**REQUEST**

The petition proposes to rezone a vacant parcel in the Plaza Midwood neighborhood to allow 18 single family attached residential units.

## PLANNING STAFF REVIEW

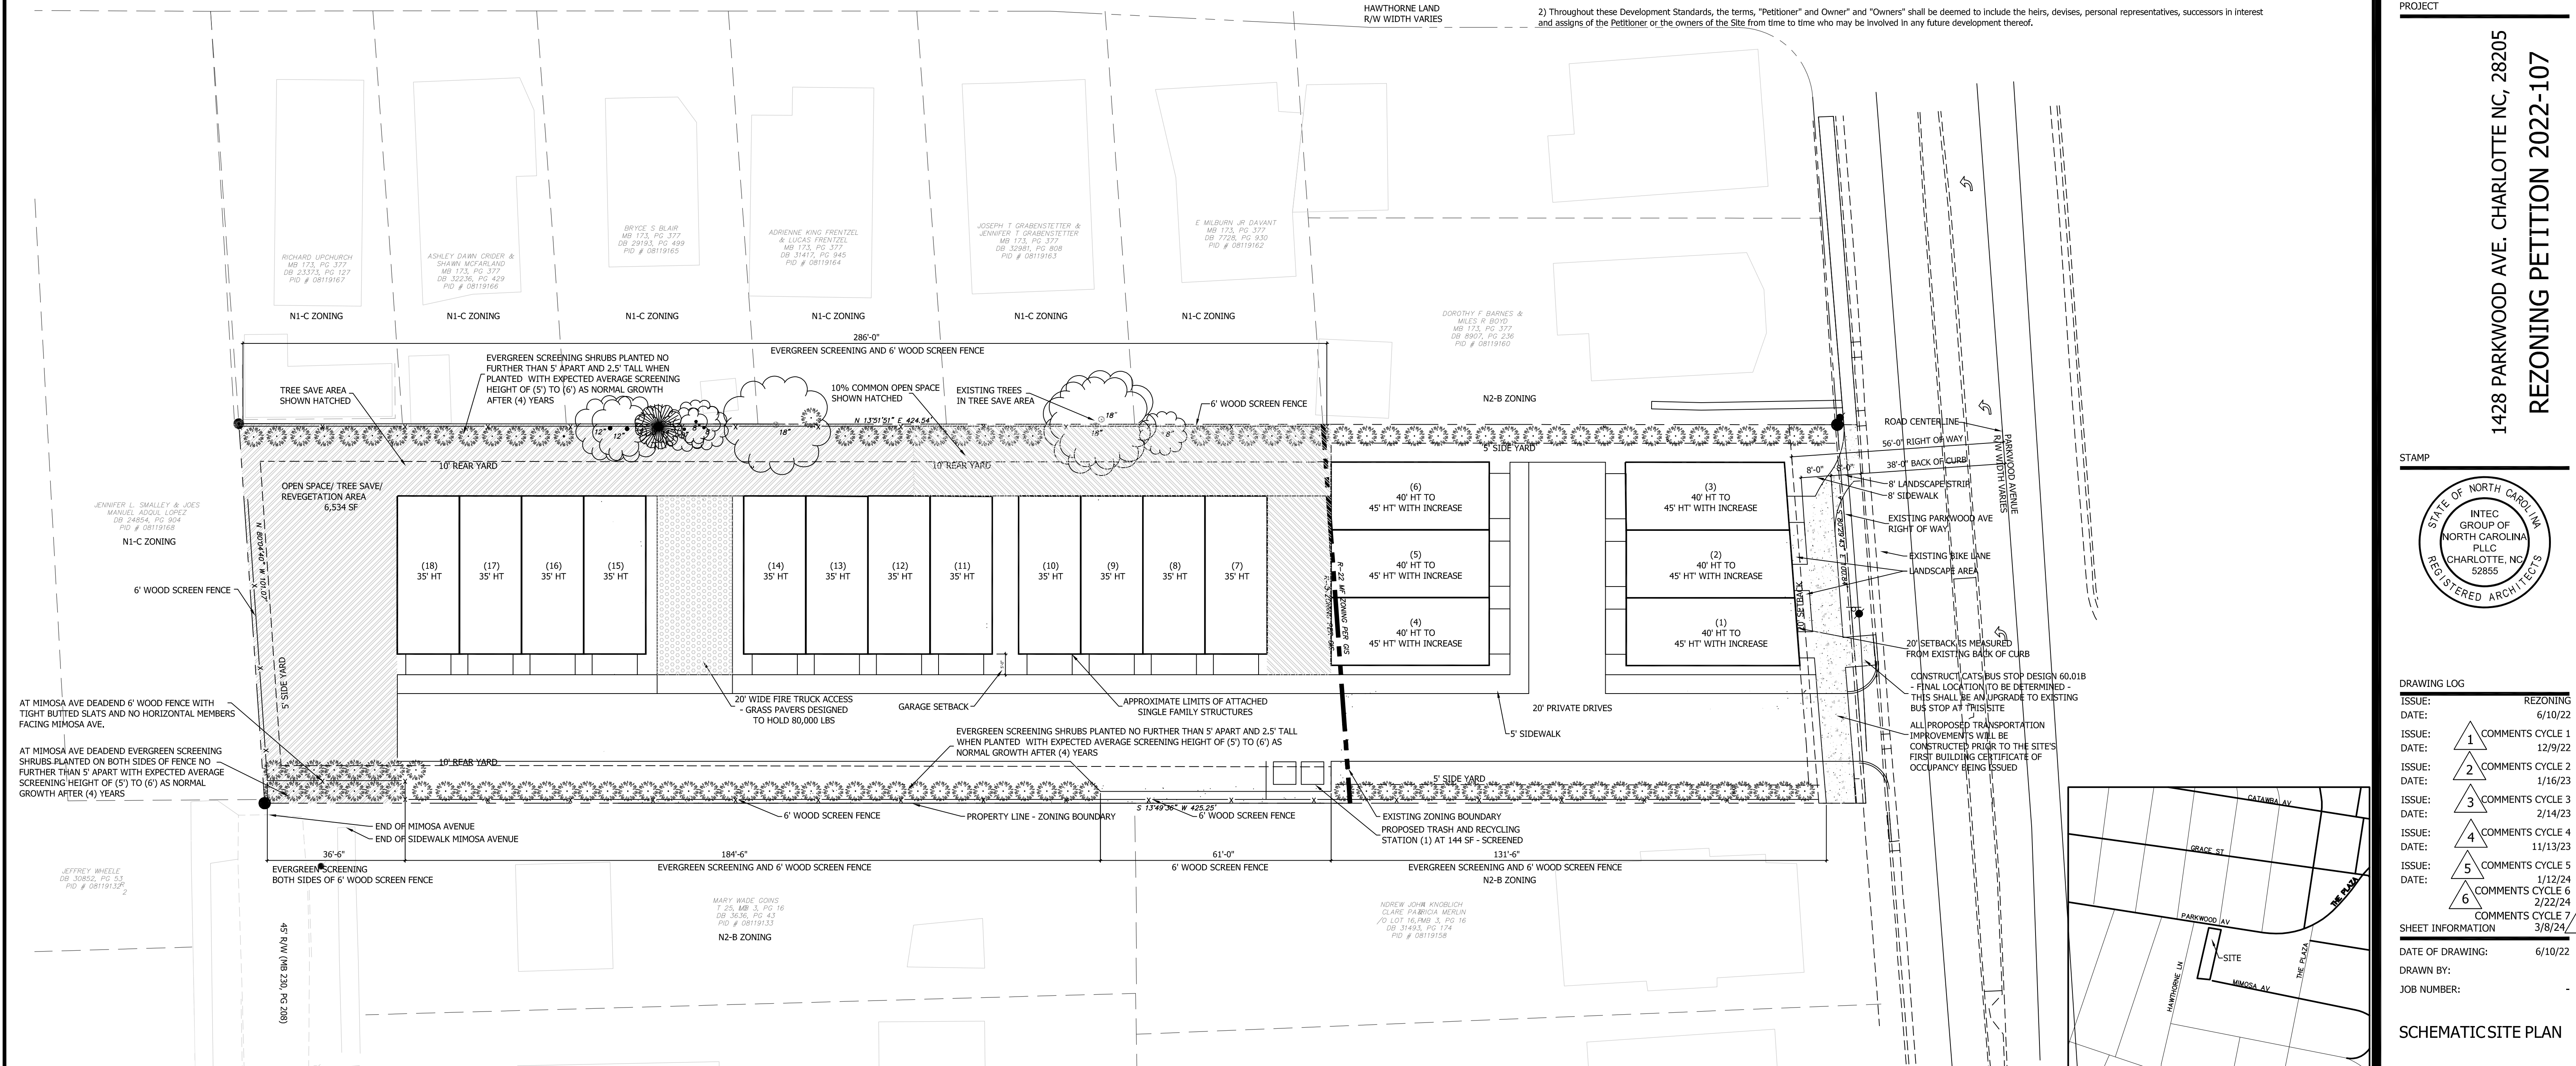
7. Please provide the width and location of the landscape screen clearly. Please ensure it noted and all the required plantings in landscape screen areas clearly defined. Add a development note committing to the landscape screen details along the east and west property lines. **Update:** Transportation Note 12 should be placed under Landscaping and Screening heading. The language should clearly identify where both

plantings and fence will be provided, and where only fencing will be provided. Please include the width of the screening (i.e. minimum 5 feet, 10 feet, etc.). **Not addressed**

10. **New comment:** Fire Truck Access cannot be counted towards tree save requirements. **Not addressed**
